TO: All Staff
FROM: Justin Turnbull, County Surveyor *ST*
DATE: July 26, 2017
SUBJECT: County Survey Review of Boundary Line Adjustment 17-00008 (Kachess)

Suggested Changes (not required)

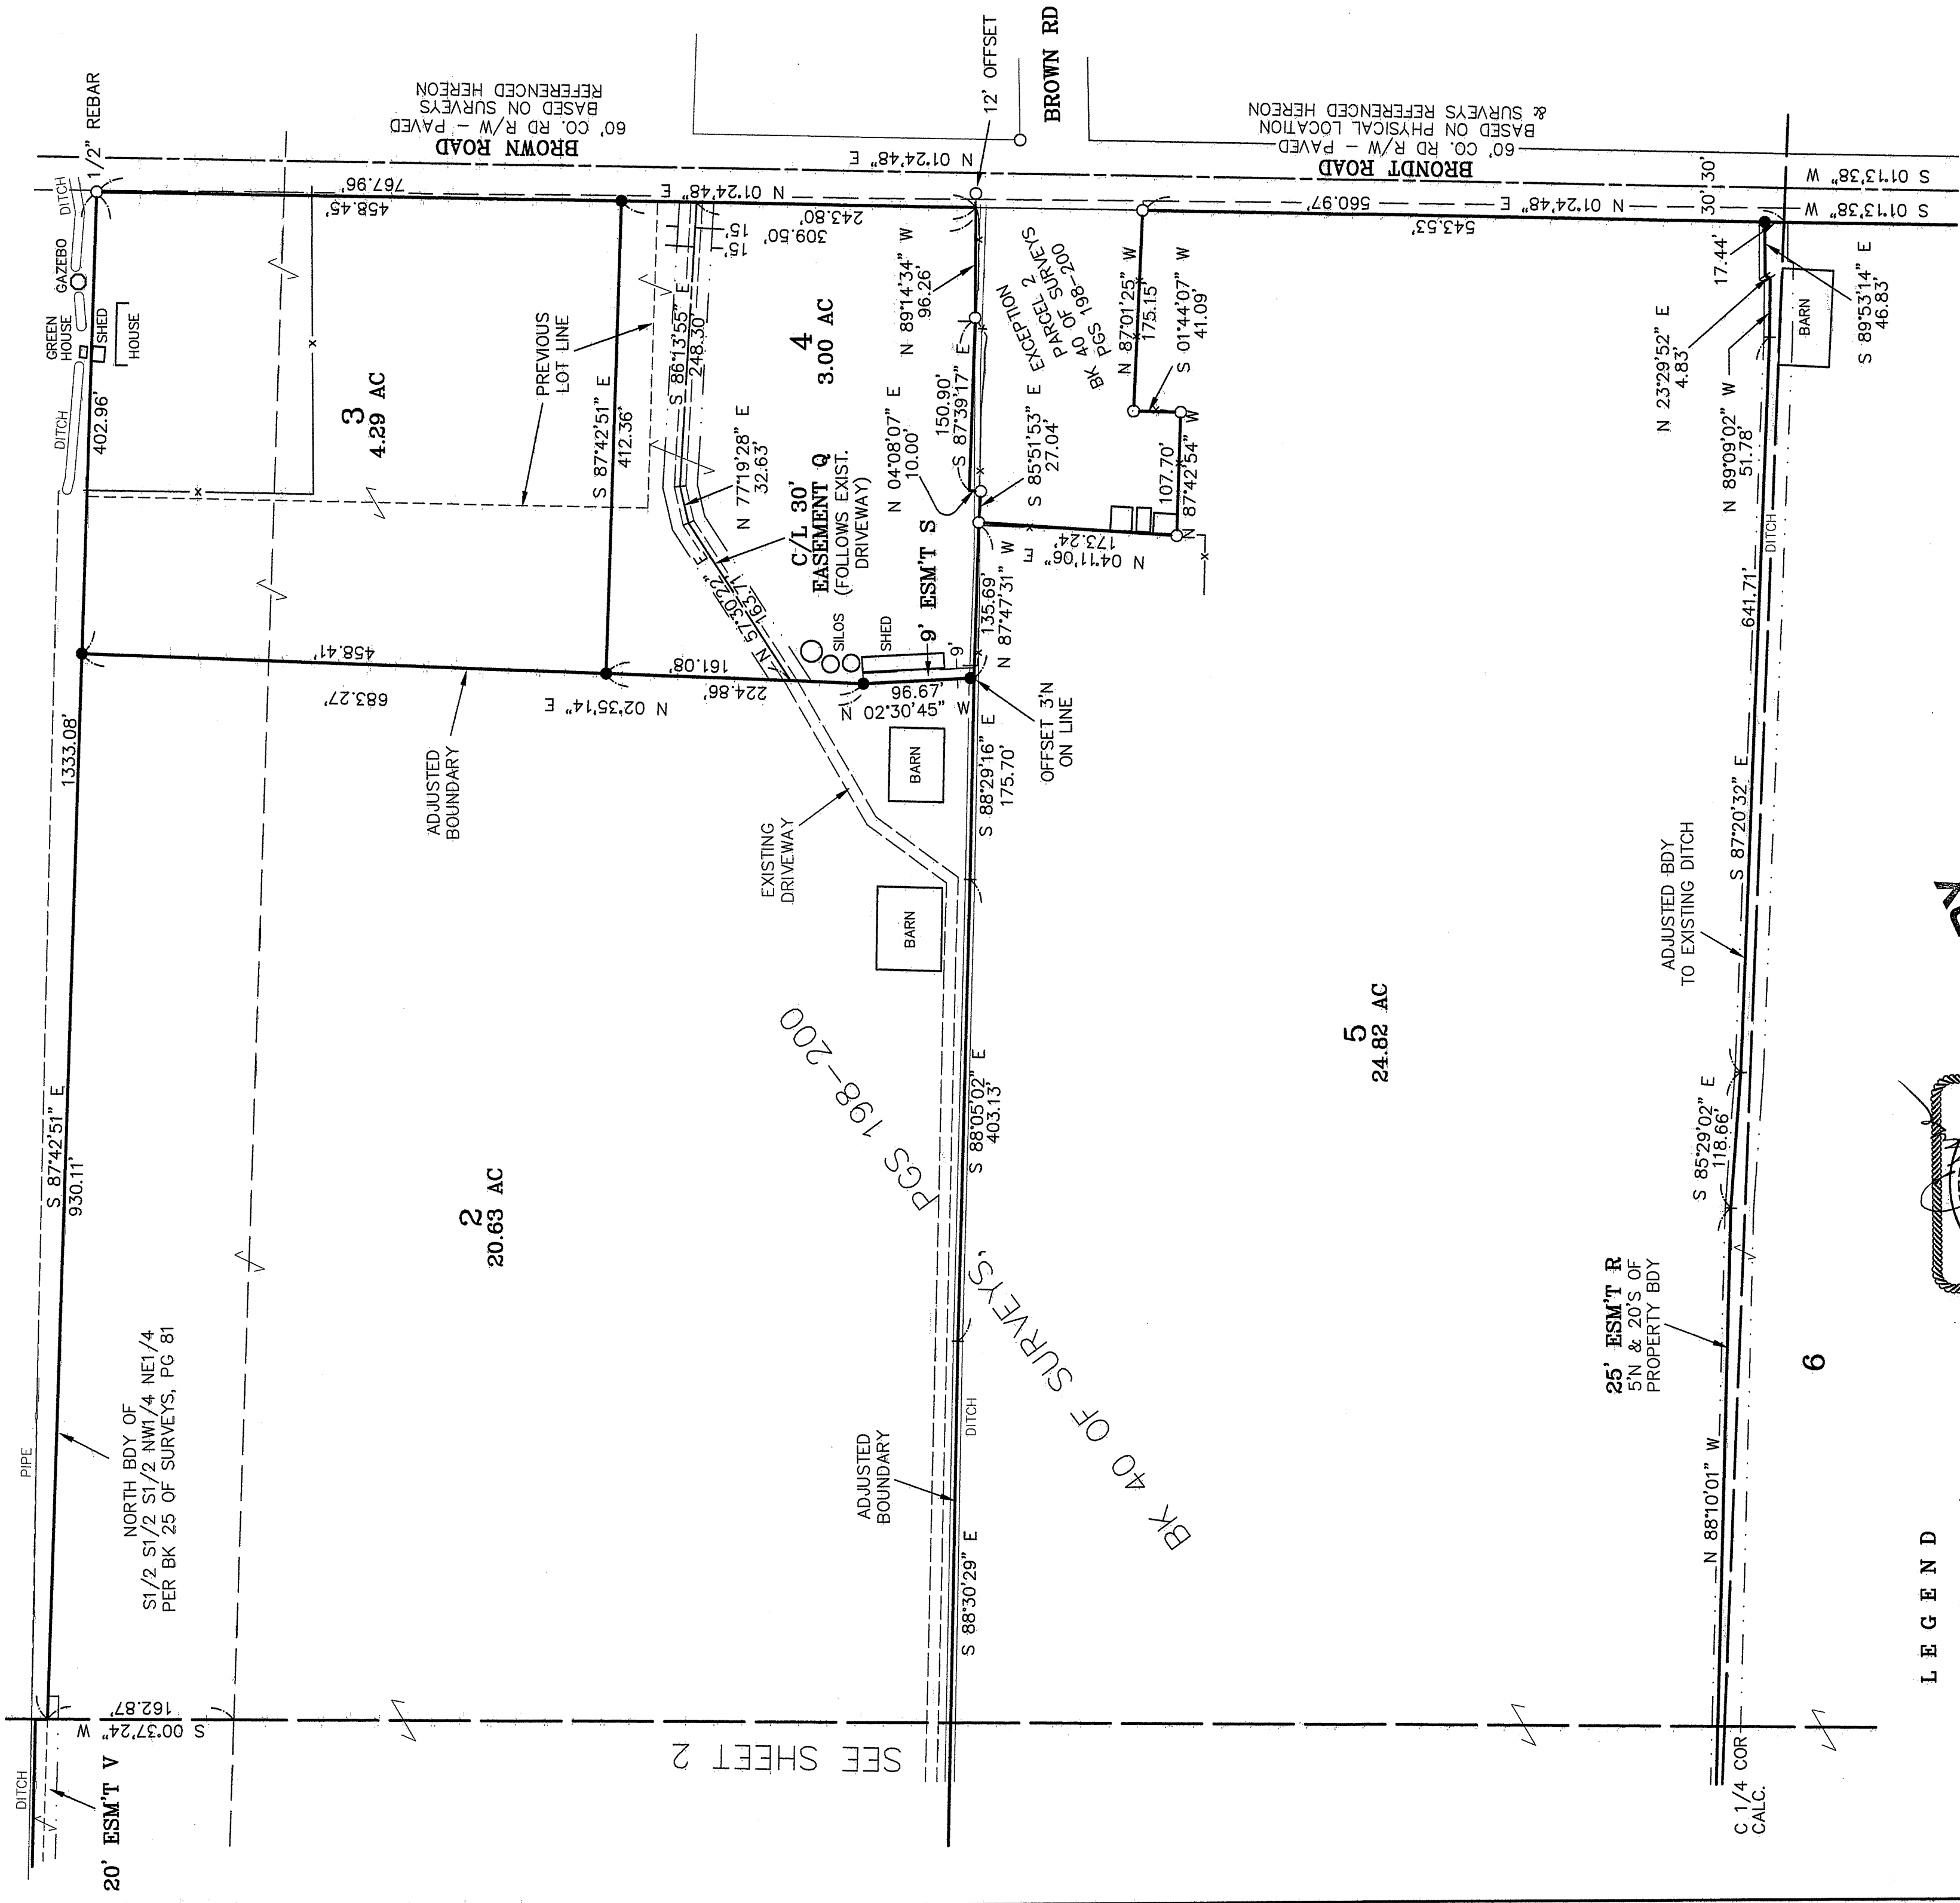
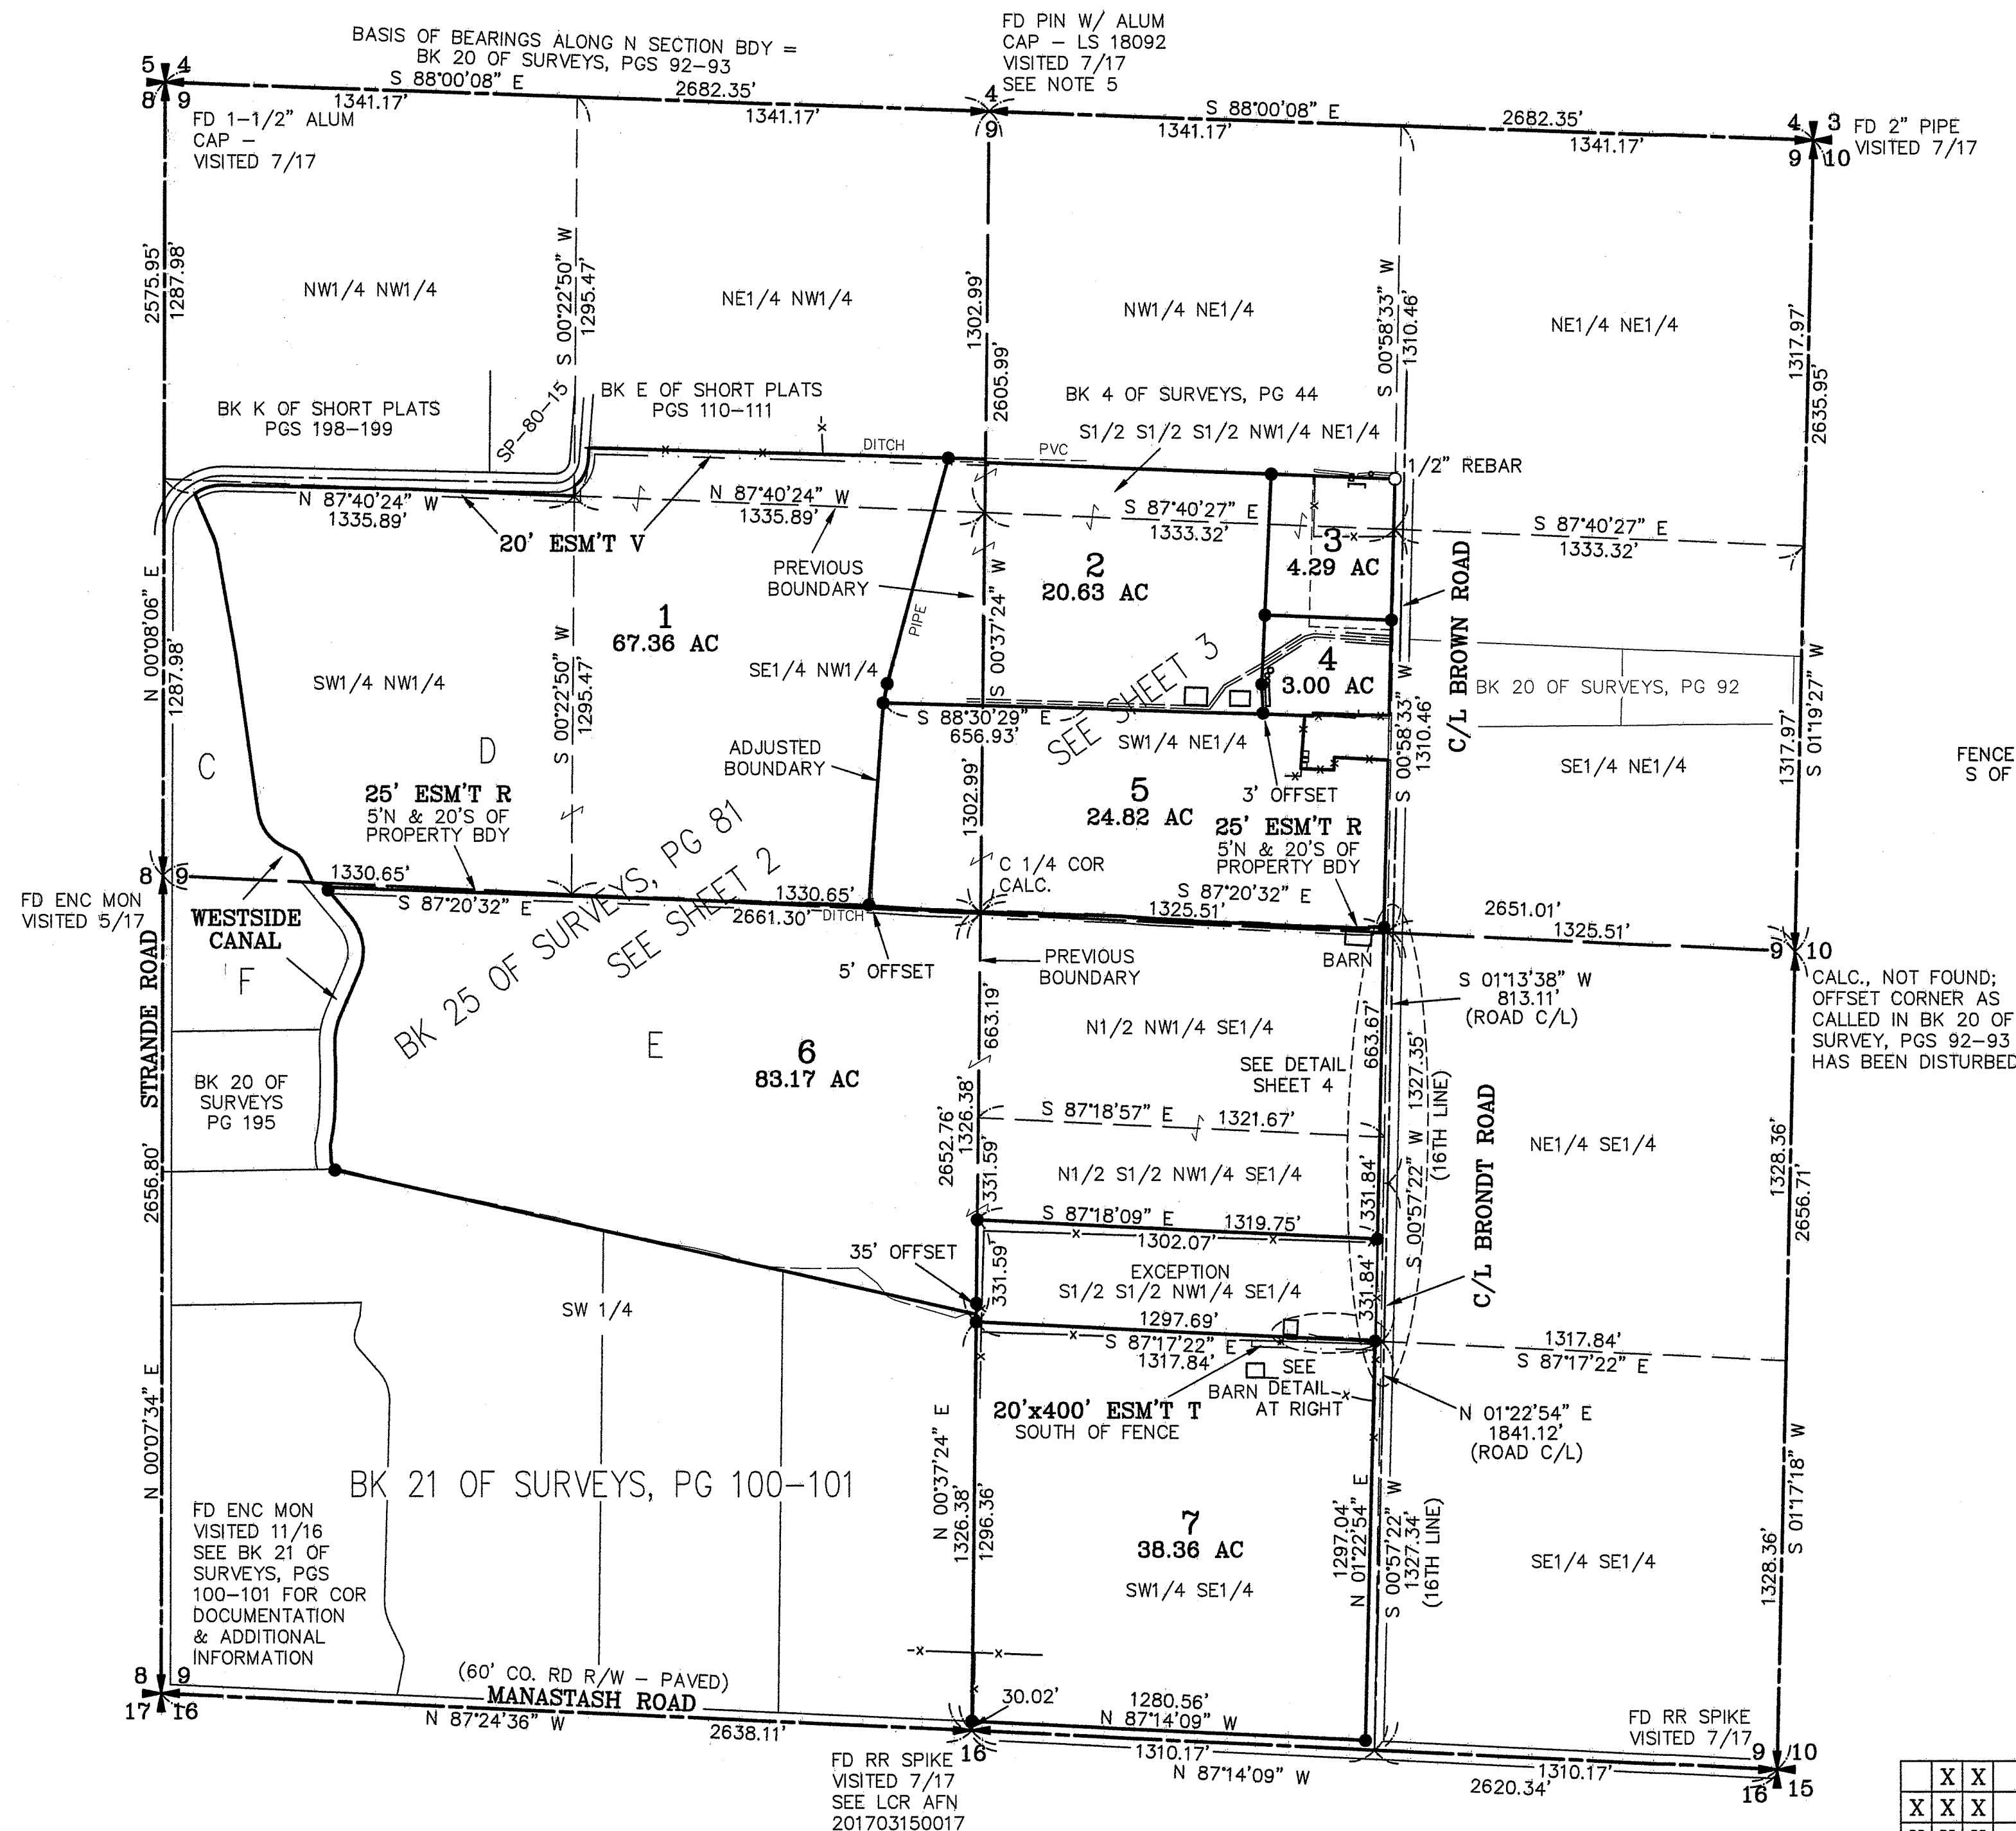
1. All easements should be labeled as "Existing", or "Created via Separate Document"(or similar). All easements should width and type of easement.
